**GLENVALE PARK – Phase 1 Local Centre
Non-material amendment application in relation to reserved
matters approval NW/22/00170/REM**

I write in relation to reserved matters approval NW/22/00170/REM for the Glenvale Park Phase 1 Site R4 Local Centre, and the proposed non-material amendment (NMA) application which seeks to update a number of plans associated with this approval.

SCHEDULE 1

**NORTH WELLINGBOROUGH LOCAL CENTRE**  
 PGR CONSTRUCTION  
 PROPOSED EAST+NORTH ELEVATIONS-FOODSTORE

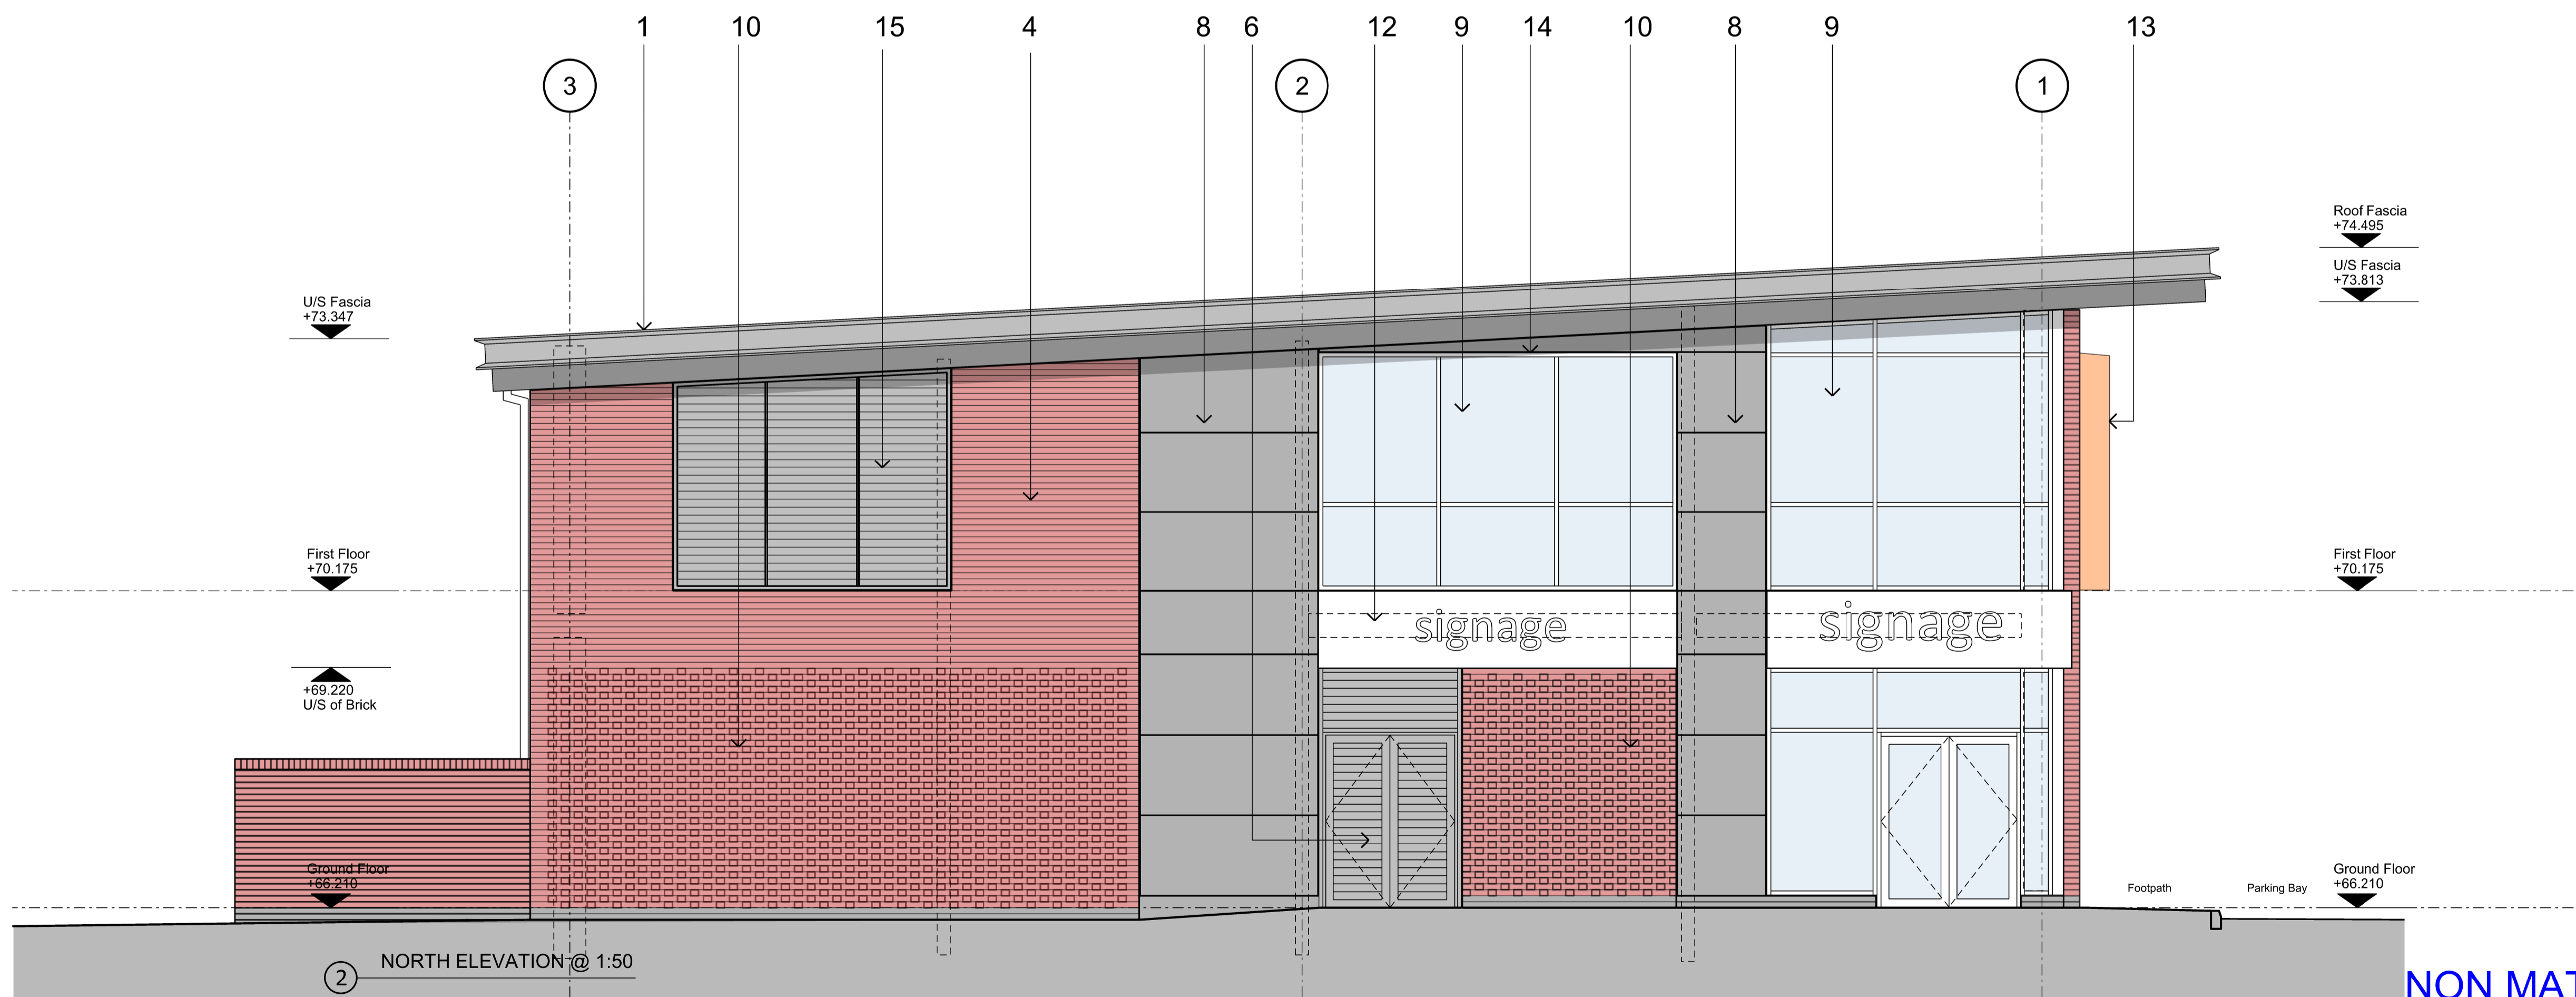
<p>D FOODSTORE APPROVED UNDER REF. NW/22/00170/REM DRAWING NO. 1033-007-P8</p>		
REF.	PROPOSED CHANGE FROM APPROVED	REASON
	DRAWING NO. 1495-408-P2 PROPOSED EAST & NORTH ELEVATIONS	
D4	EAST ELEVATION: EXTERNAL METAL FACED DOOR ADDED	TENANT REQUIREMENT

NORTH WELLINGBOROUGH LOCAL CENTRE  
PGR CONSTRUCTION  
PROPOSED SOUTH+WEST ELEVATIONS-FOODSTORE  
DATE NOV 2023  
DRAWING NUMBER 1495-407

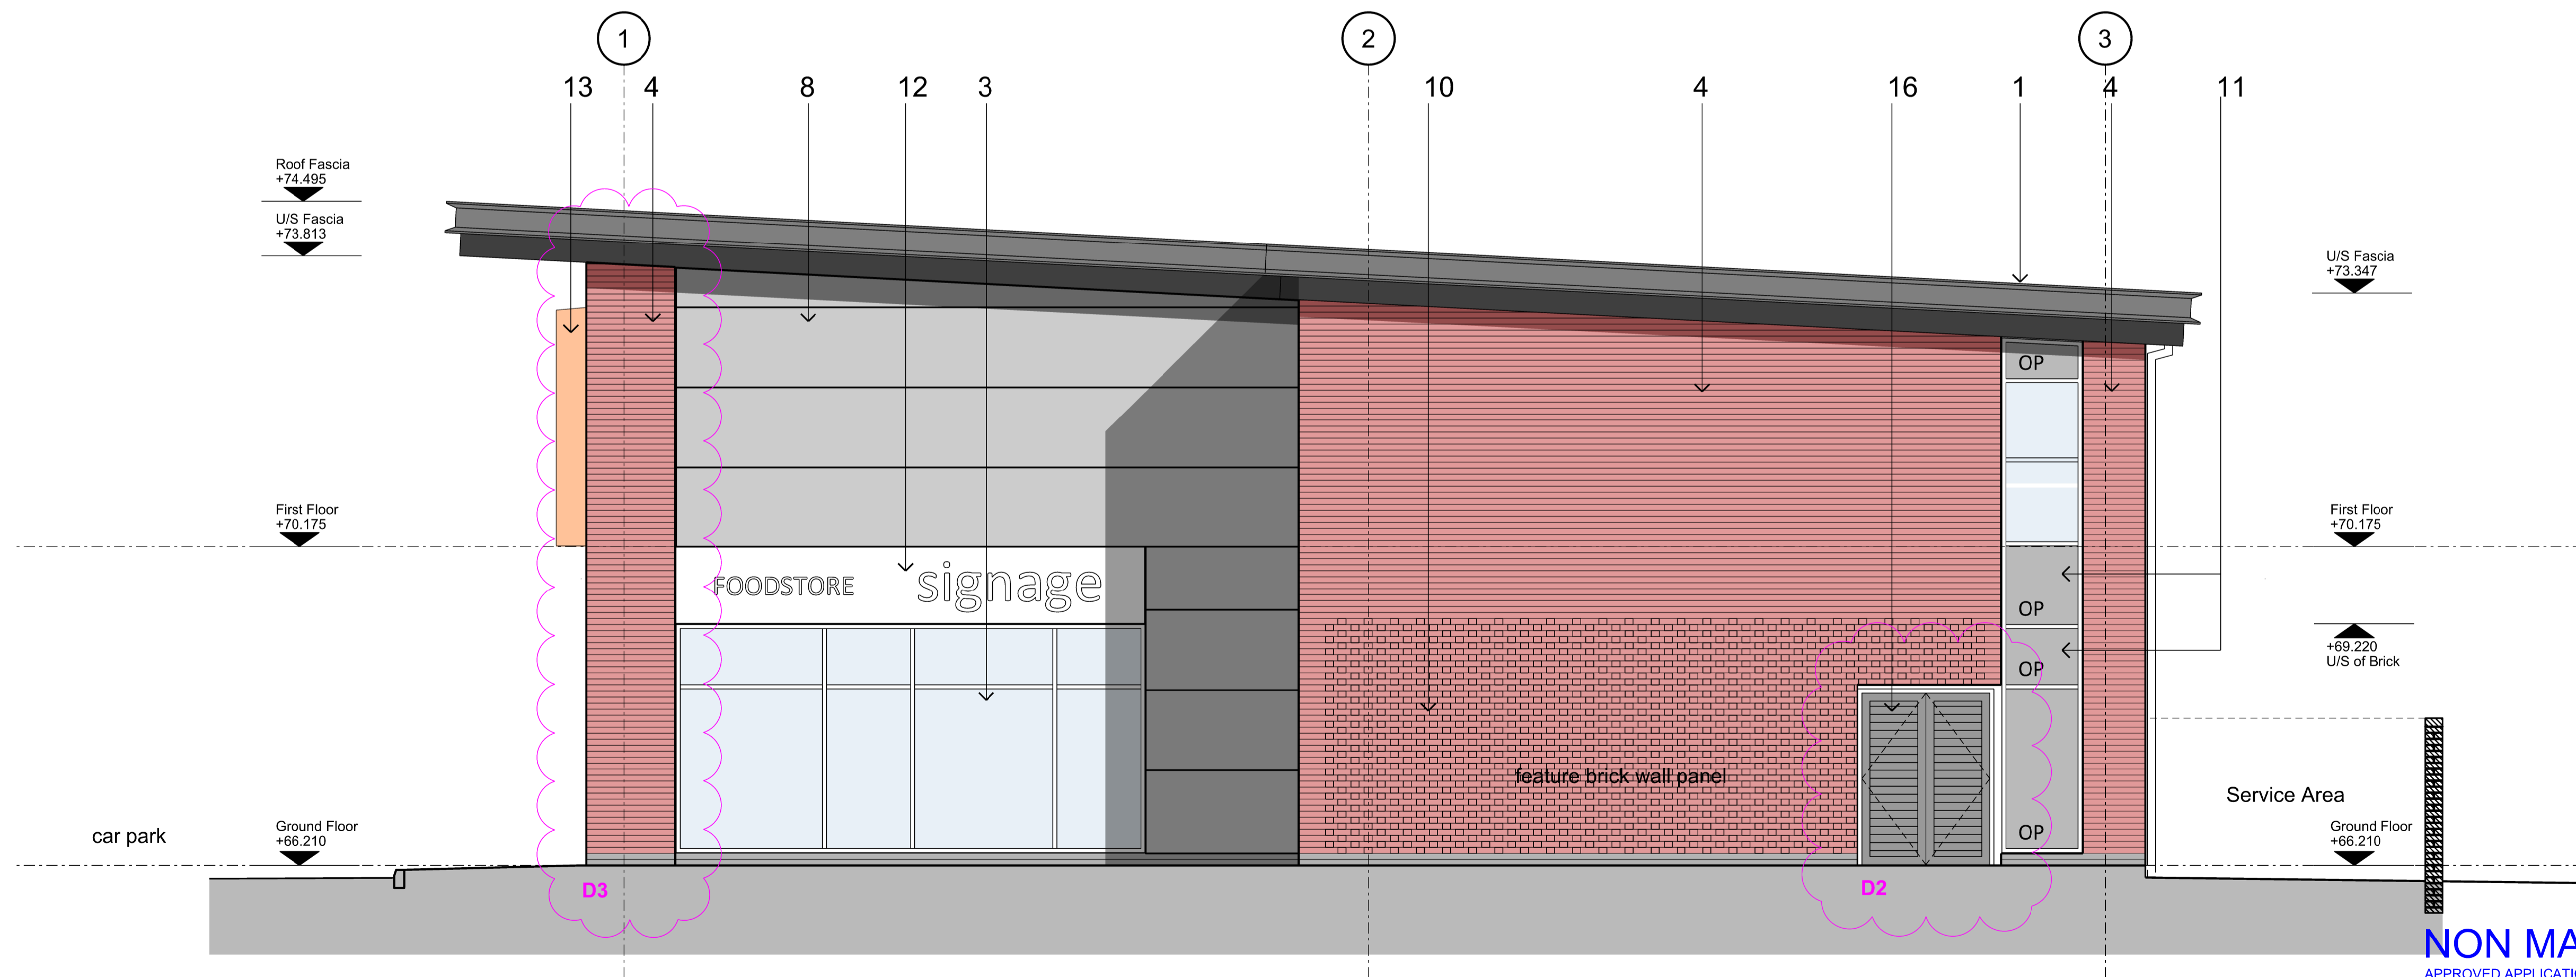
D FOODSTORE APPROVED UNDER REF. NW/22/00170/REM DRAWING NO. 1033-007-P8		
REF.	PROPOSED CHANGE FROM APPROVED	REASON
	DRAWING NO. 1495-407-P4 PROPOSED SOUTH & WEST ELEVATIONS	
D1	WEST ELEVATION: BRICK PANELS ON 1ST FLOOR CHANGED TO FLAT HORIZONTAL CLADDING PANELS.	CHANGES TO EXTERNAL MATERIALS: DECISION TO CONSTRUCT THE COLUMNS ON THE FRONTAGE (WEST ELEVATION) IN BRICKWORK RATHER THAN CLADDING, MAKING THEM FAR MORE ROBUST AND ABLE TO WITHSTAND BUMPS AND SCRATCHES FROM TROLLEYS. OVERALL MATERIAL PALETTE REMAINS THE SAME - MATERIALS HAVE BEEN RE-POSITIONED TO ADDRESS BUILDABILITY AND LONGEVITY. VISUALLY THE CHANGES ARE MINIMAL.
D1(a)	BRICK COLUMNS IN LIEU OF METAL CLADDING.	
D2	SOUTH ELEVATION: EXTERNAL METAL LOUVRED DOUBLE LEAF DOOR ADDED.	ACCESS TO PLANT ROOM/STORE. STORE PROVISION UNDERNEATH THE STAIRS FOR UNIT 7.
D3	BRICK PIER IN LIEU OF METAL CLADDING AT CORNER.	BUILDABILITY & CONSTRUCTION.
